West House  
South Strand  
East Preston  
West Sussex  
BN16 1PN

I am writing to object to the planning application: EP/70/12.

1207 SK26
 Sandgate House, East Preston
 Elevations As Proposed - sheet 2
 June 2012
 scale: 1:100

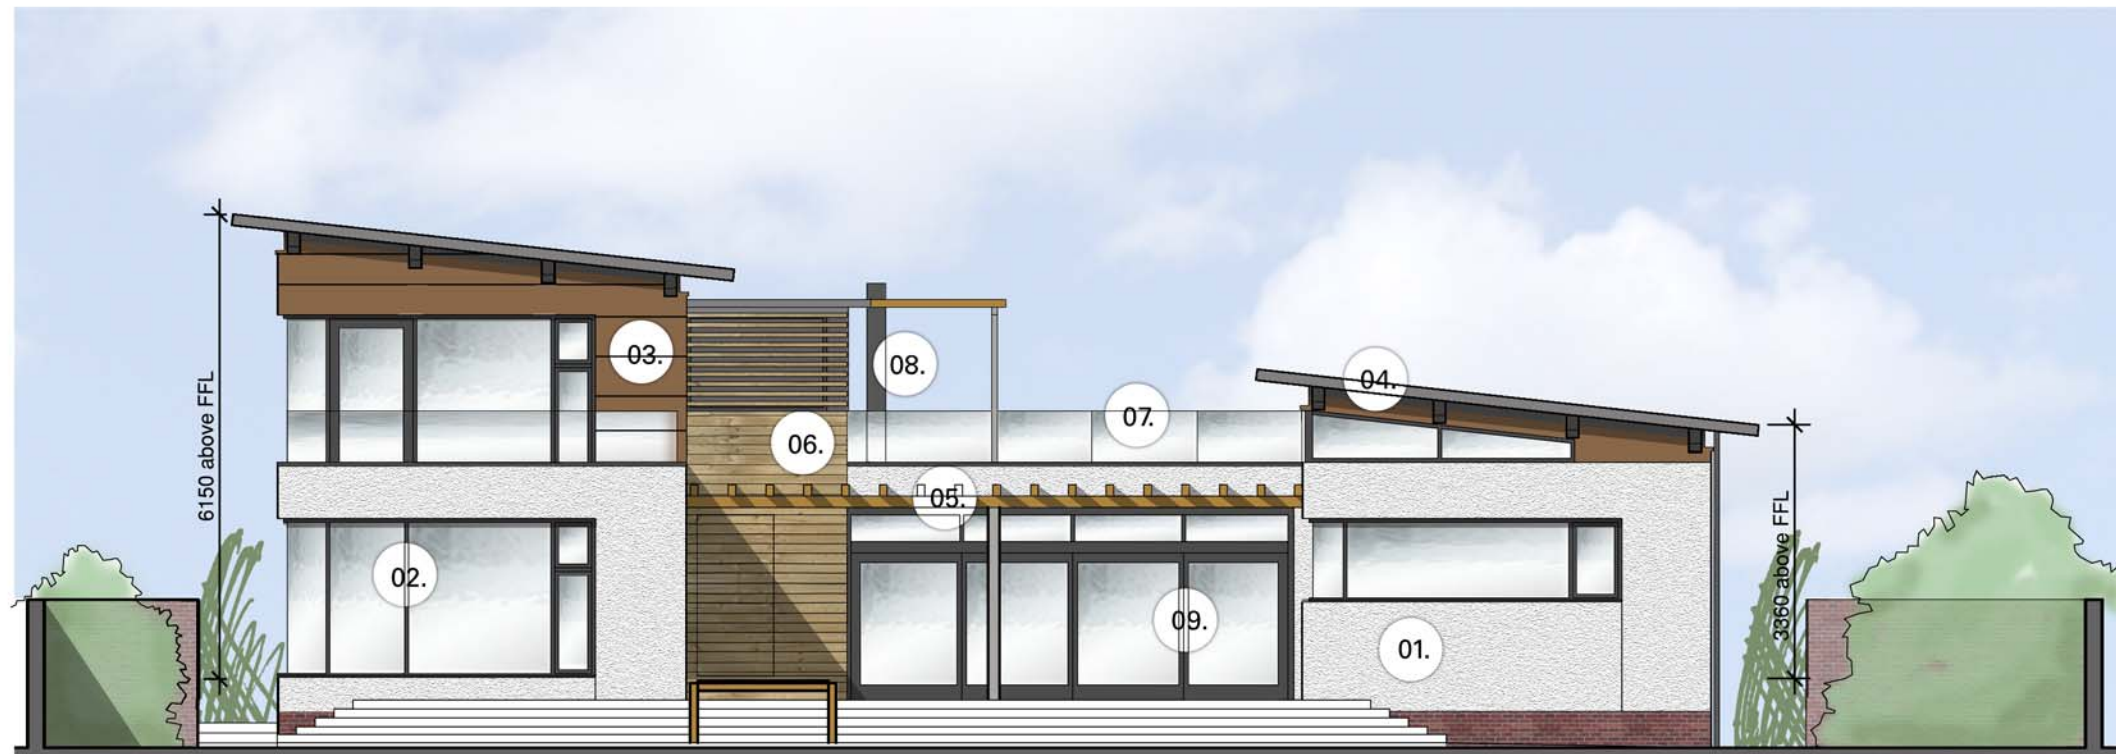
I am also concerned about the increased height of Sandgate House if the alterations take place. Although the existing roof is to be replaced with a lower mono pitched roof, it is unclear whether the alterations to the first floor will result in a taller property

overall. If this is the case, it will blight the sea view of nearby properties, including mine.
